## Department of Primary Industries

OUT16/24451

**Mount Owens Continued Operations Project (SSD 5850)  
Comment on the Response to Planning Assessment Commission Review Report**

28 June 2016

FIGURE 1
Mount Owen Continued Operations Project Conceptual Final Landform

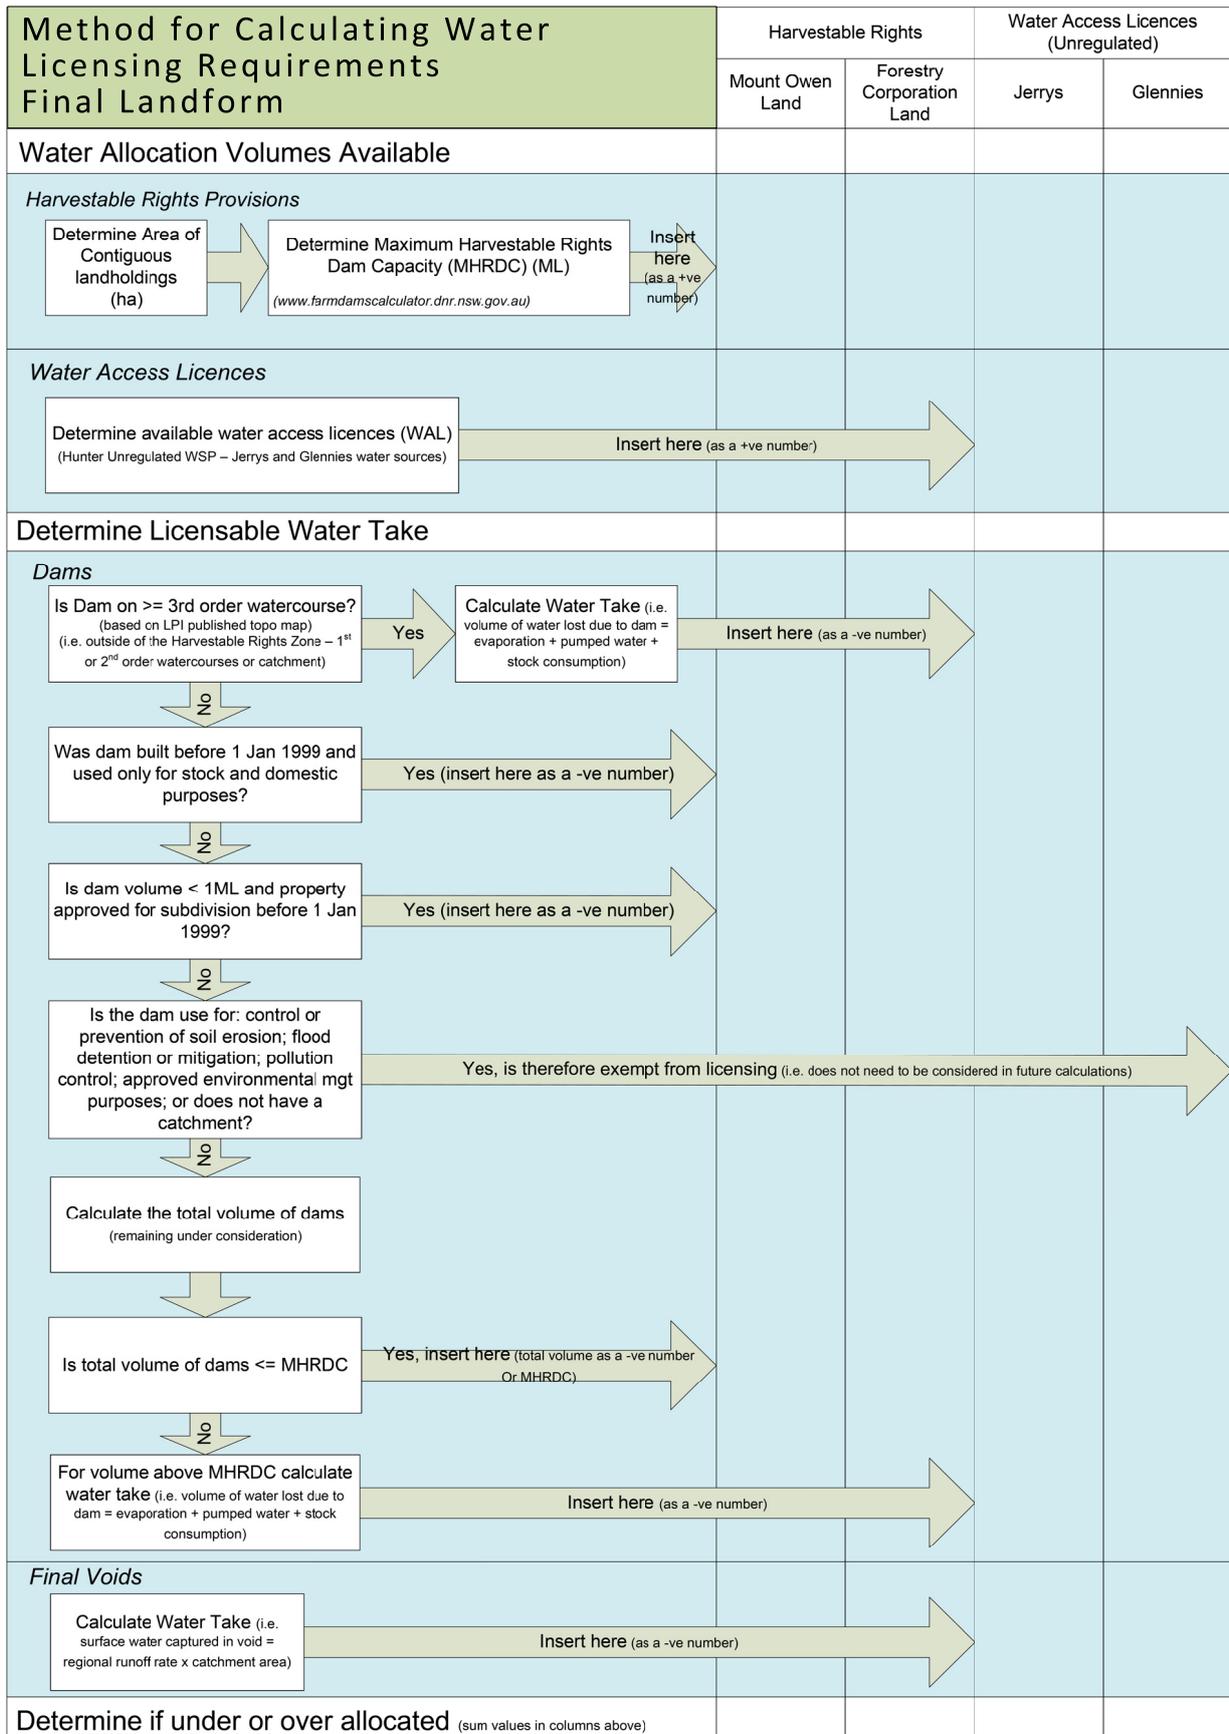
- With reference to Figure 6.1 *Conceptual Final Landform Water Licensing and Accounting Framework*, DPI Water advises that stock and domestic dams built prior to 1 January 1999 and dams less than 1 Megalitre (ML) on a property approved for subdivision prior to 1 January 1999 must be included in calculations of Maximum Harvestable Right when calculating licensing requirements and additional storage construction. The proponent should clarify whether this has been accounted for in the licensing requirements as detailed in Table 2.7 in Appendix 6.
